PROJECT NO.
25-080.00

GRAND MOUNTAIN SCHOOL
MODULAR CLASSROOM
PPR AMENDMENT

LANDSCAPE PLAN
SHEET 4 OF 7
A1.2

A1.2

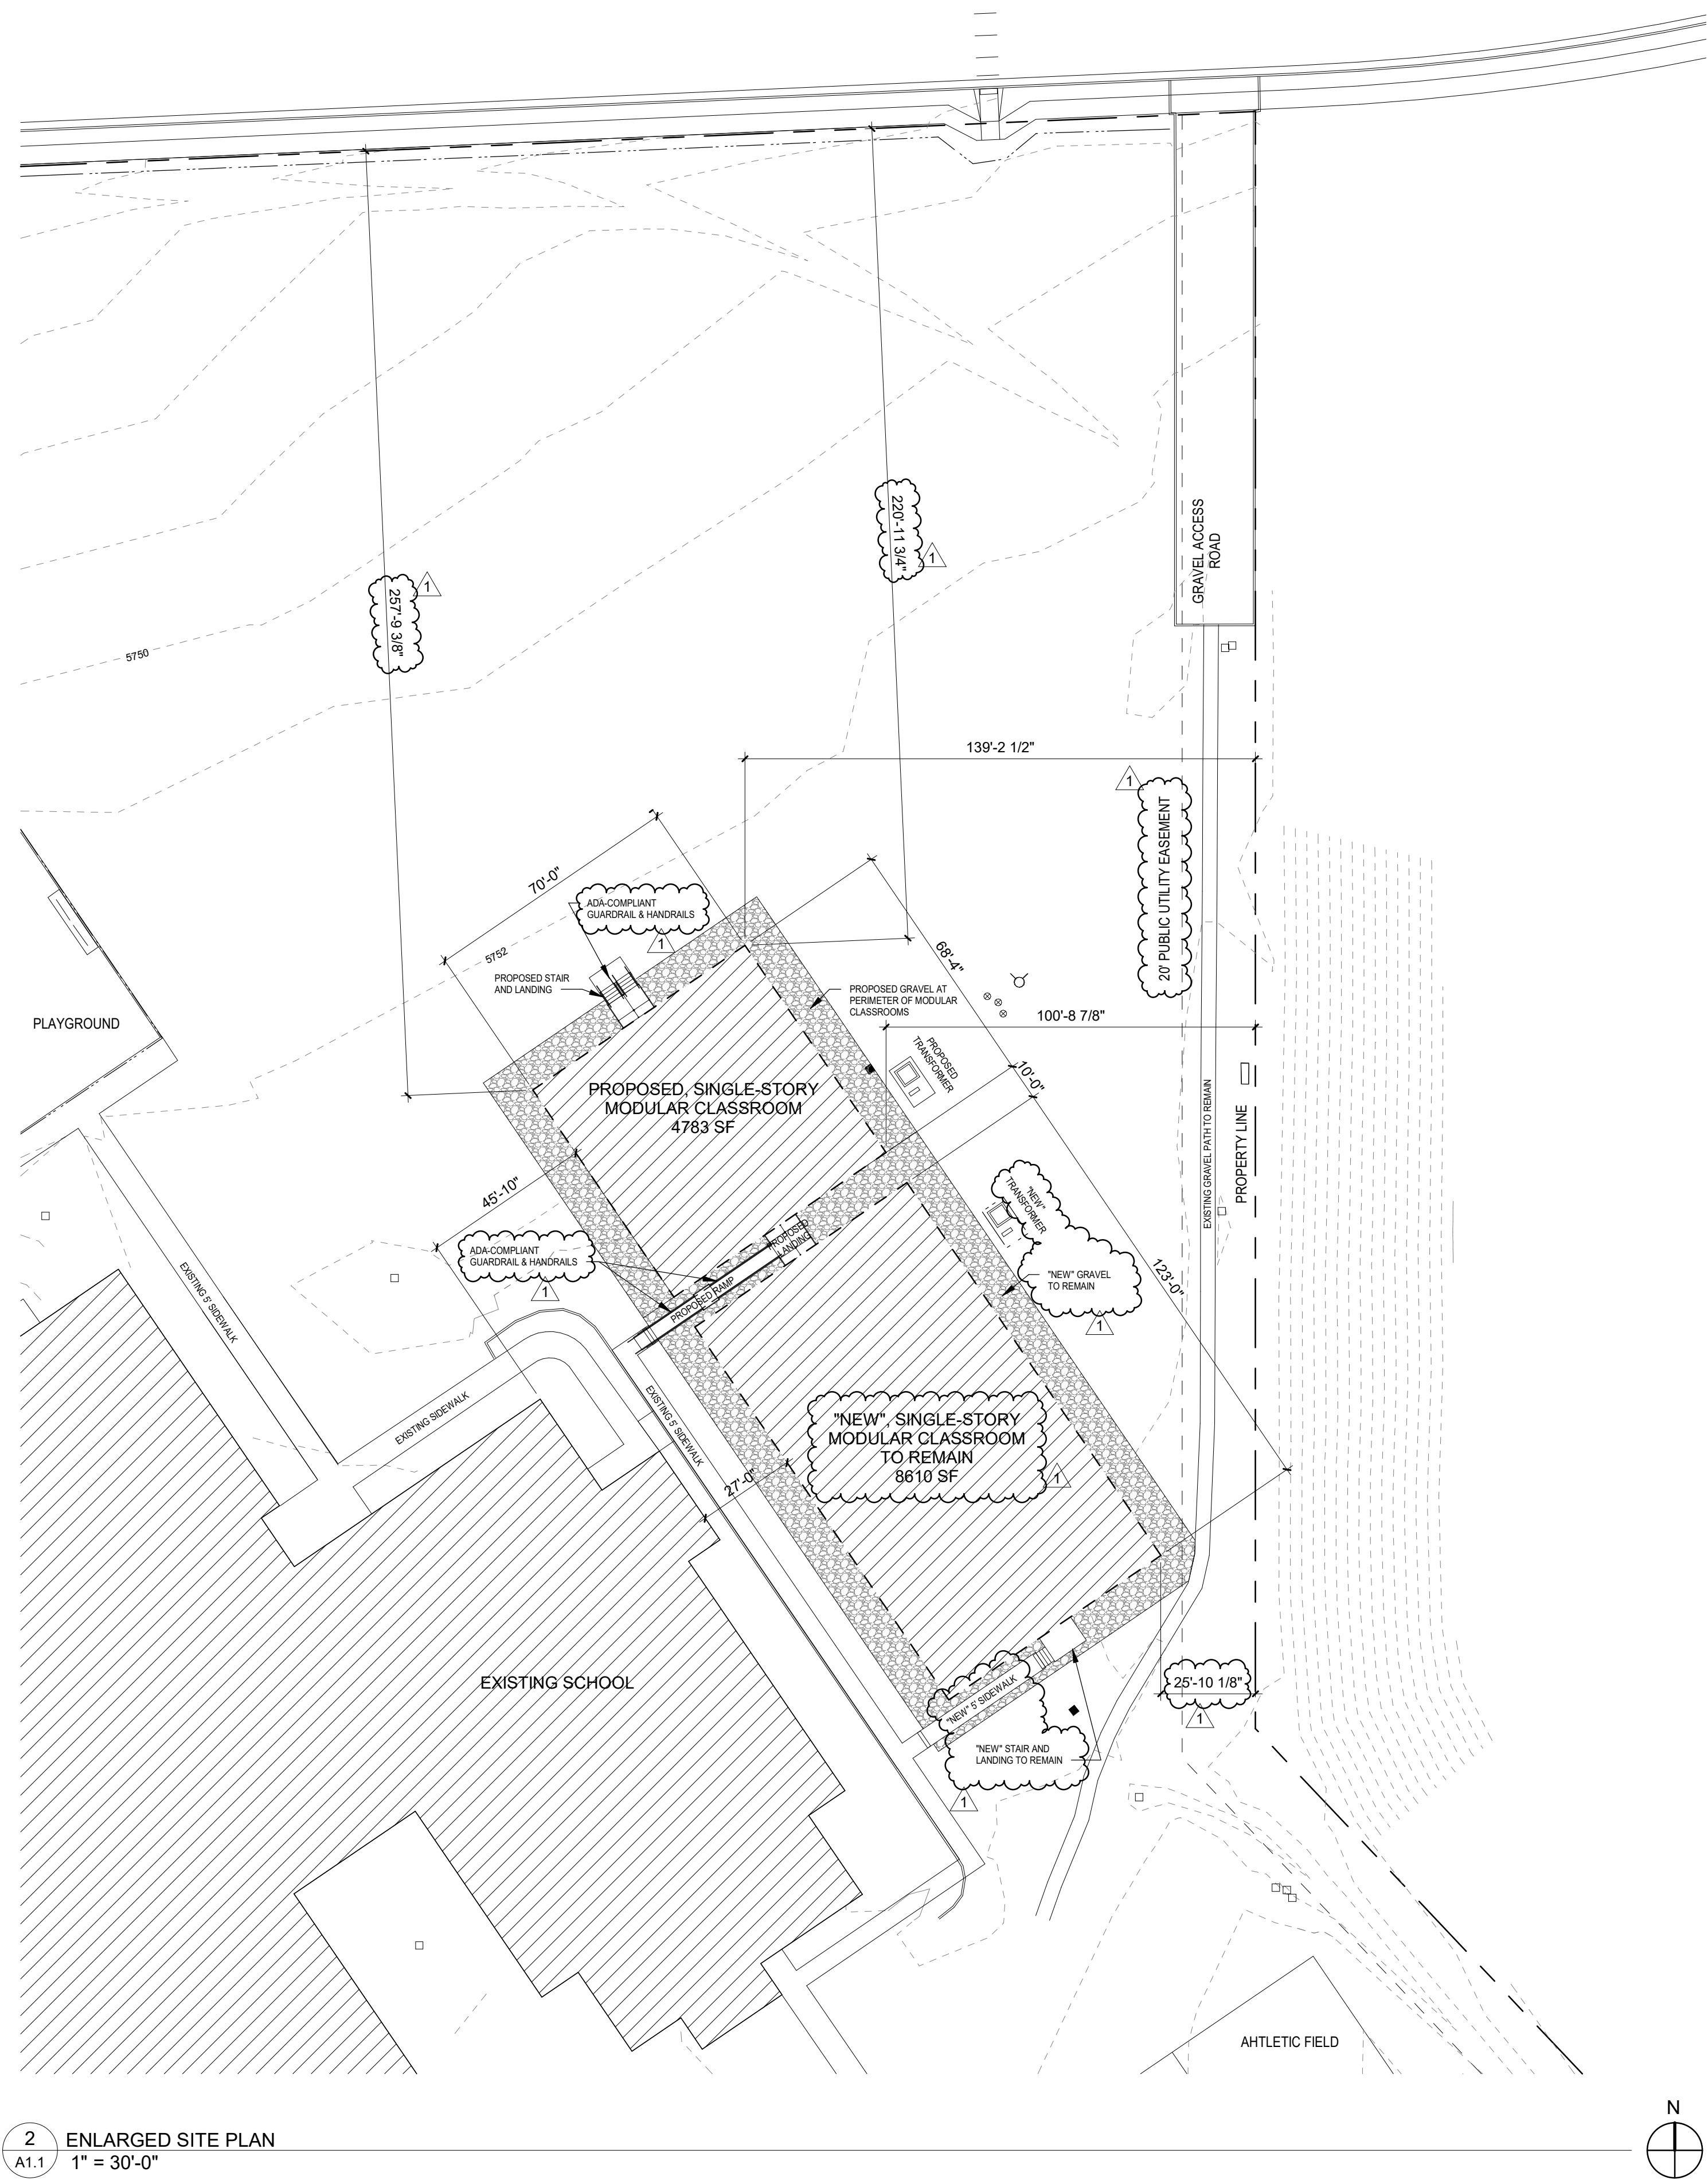
Landscaping Plan approved under initial Site Development Plan review is found under EDARP file number PPR1826. The portion of focus for this project is found below. Please include all existing landscaping on the current Landscaping Plan document. If landscaping in the subject area no longer exists due to site changes, please reinstate and show on the current document.

Land Development Code 6.2.2.D.2
Please relocate the previously approved landscaping east of the proposed moduls. (Buffer to adjacent residential.) This will satisfy the Code section below.

- (iii) On the residential side of the project when use to use compatibility is a concern.
 - (b) **Depth and Planting Standards.** The required buffer shall be a minimum of 15 feet deep. The minimum number of trees in the buffer shall be 1 tree for every 25 feet of common lot, parcel, or tract line. A minimum of 1/3 of the trees shall be evergreen trees.

- (c) **Opaque Fencing or Wall Required.** An opaque fence or wall with a minimum height of 6 feet is required along the lot, parcel, or tract line except where the adjacent single-family or duplex residential zoning district or use abuts a required roadway landscaping area.
